From:
Sent: 24 January 2023 18:07
To: DCAdmin
Cc: Nick Hirst
Subject: Planning Application 2020/93954 - Road Widening
Attachments: road widening.pdf

Please find attached a personal comment concerning the revised housing development off Lingards Road.

Project HOUSING AT LINGARDS RD SLATWATE	
Client SB HOMES LTD	
Drawing SITE SECTIONS ACROSS LINGARDS RD	
Scale 1:200	Date 19.07.22
Dwg No 2019 572 61	Rev

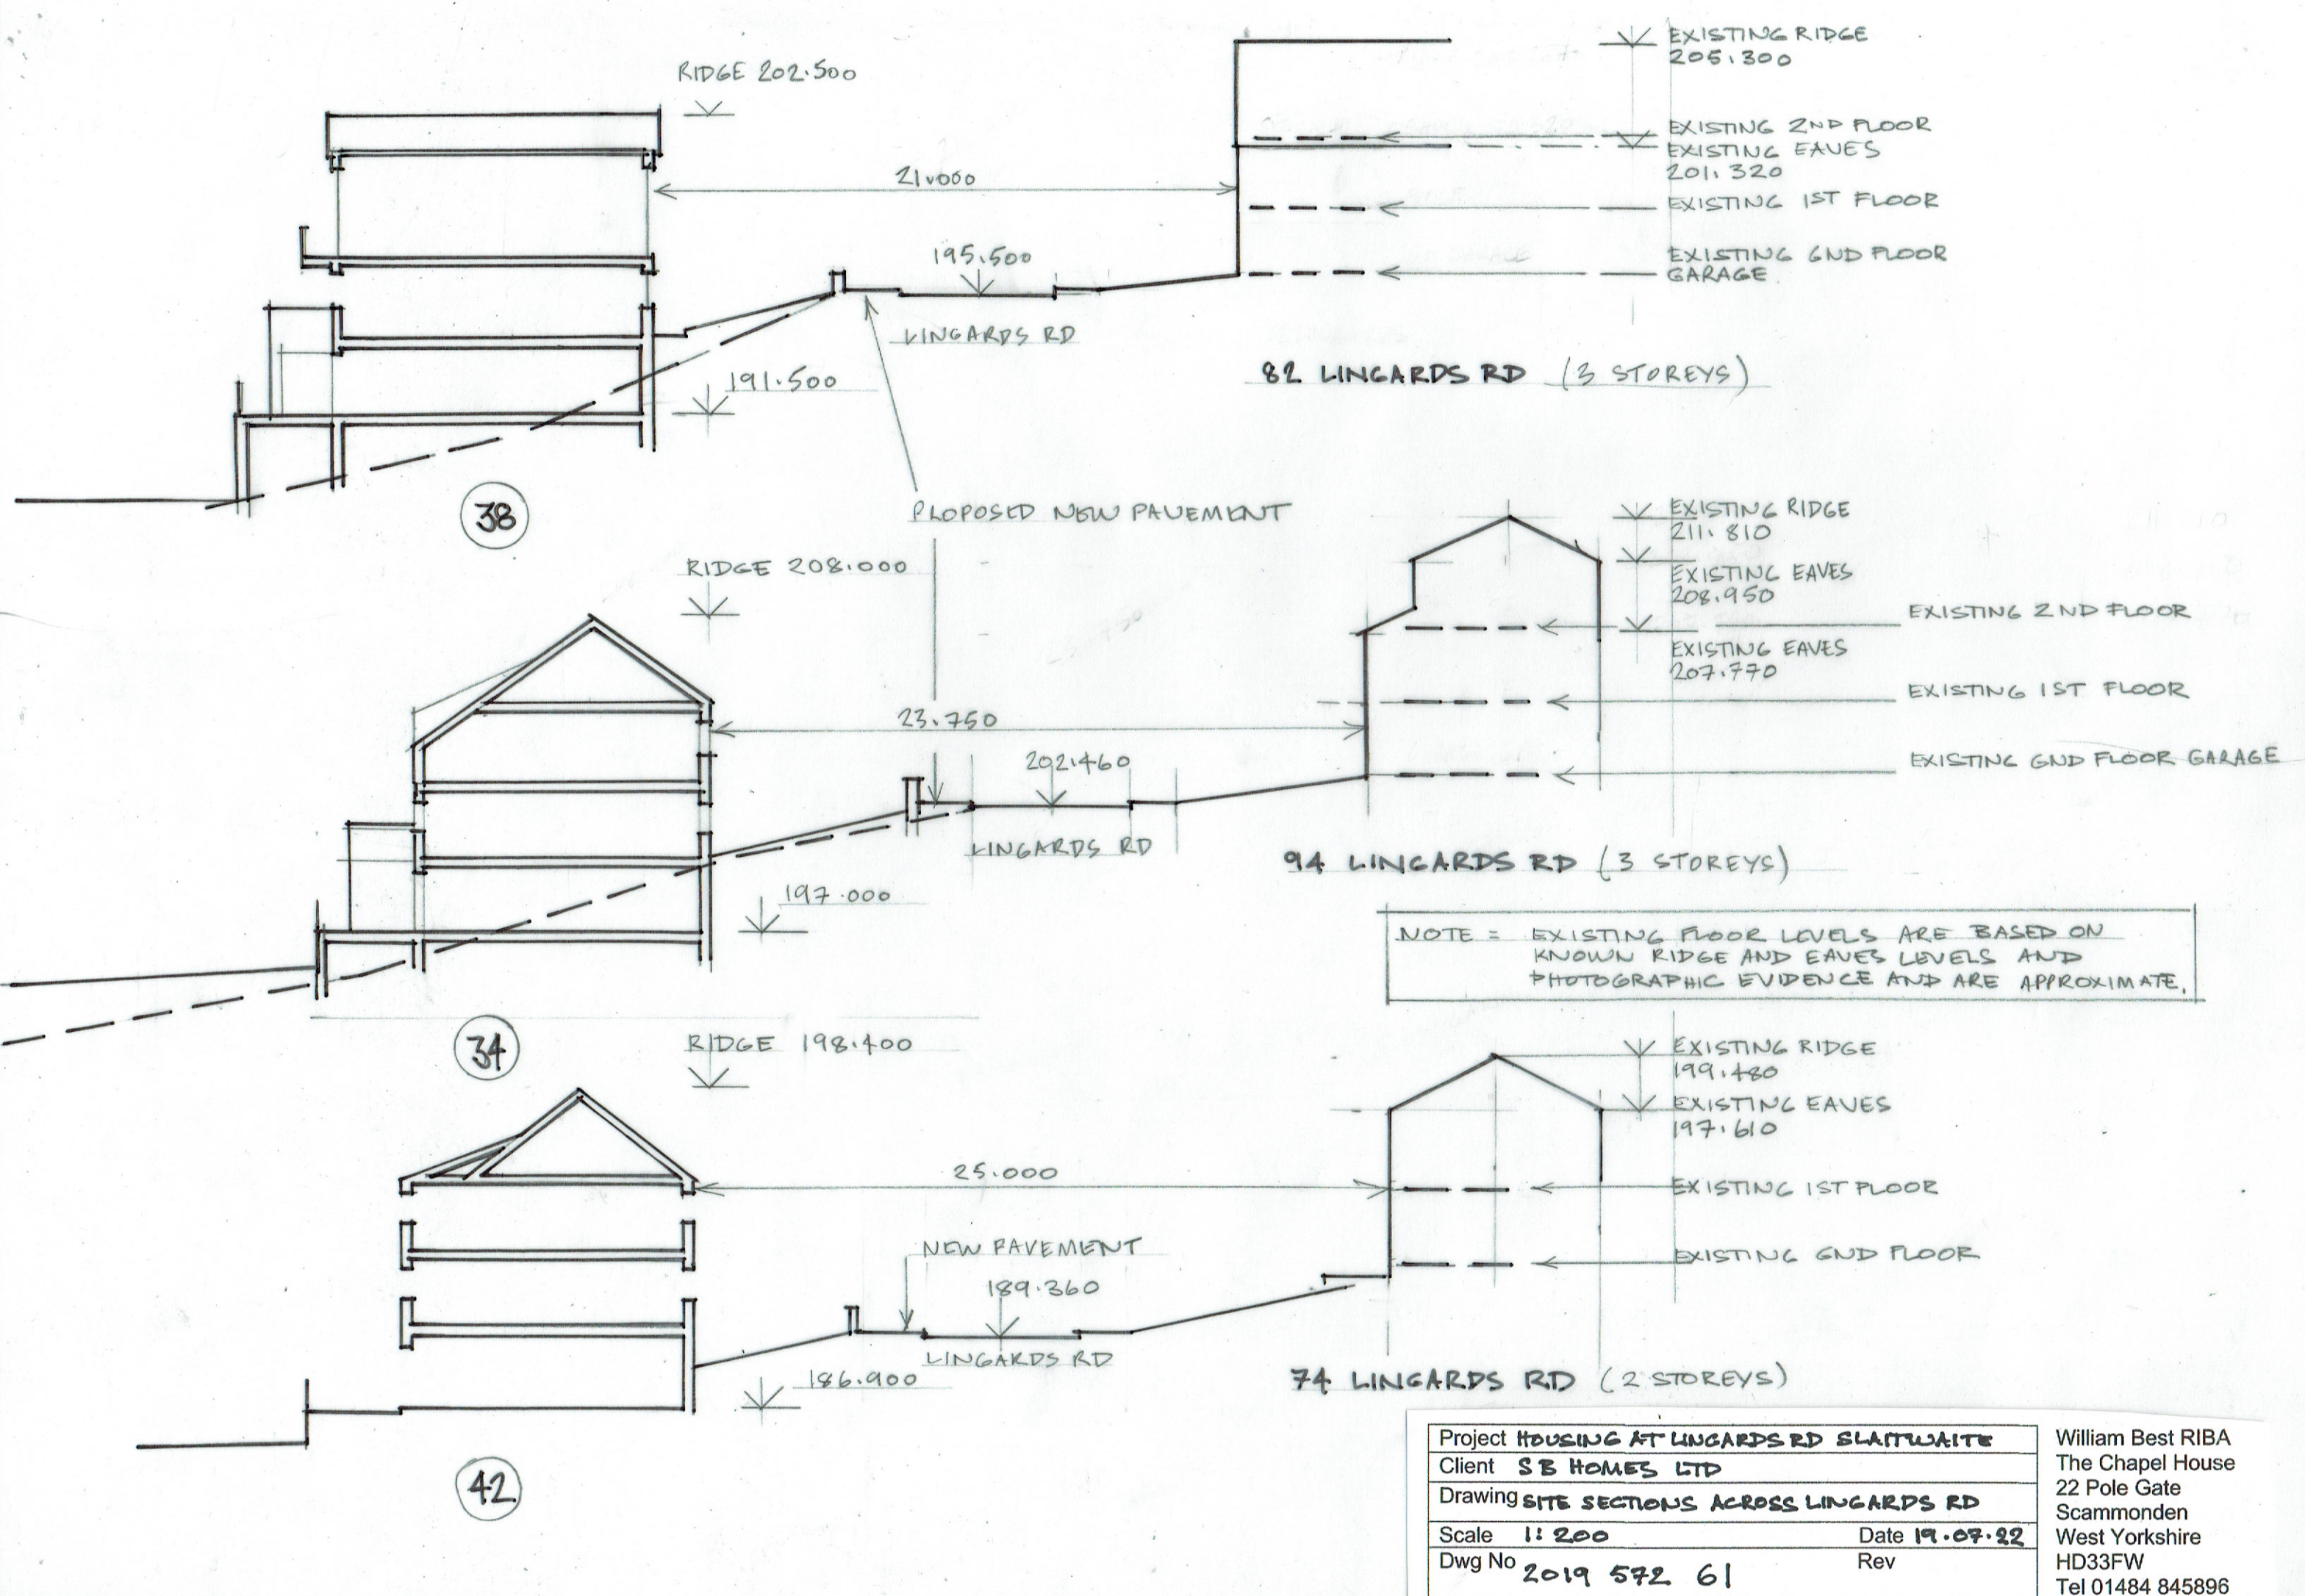
I'm sure that too would be welcomed by residents, as this application, and planners, seem happy to keep the road exactly the width it is, except near the proposed junction.

Through this application, and by design, on street parking would become an issue on Lingards Road.

It needs addressing, as an integral part of this application.
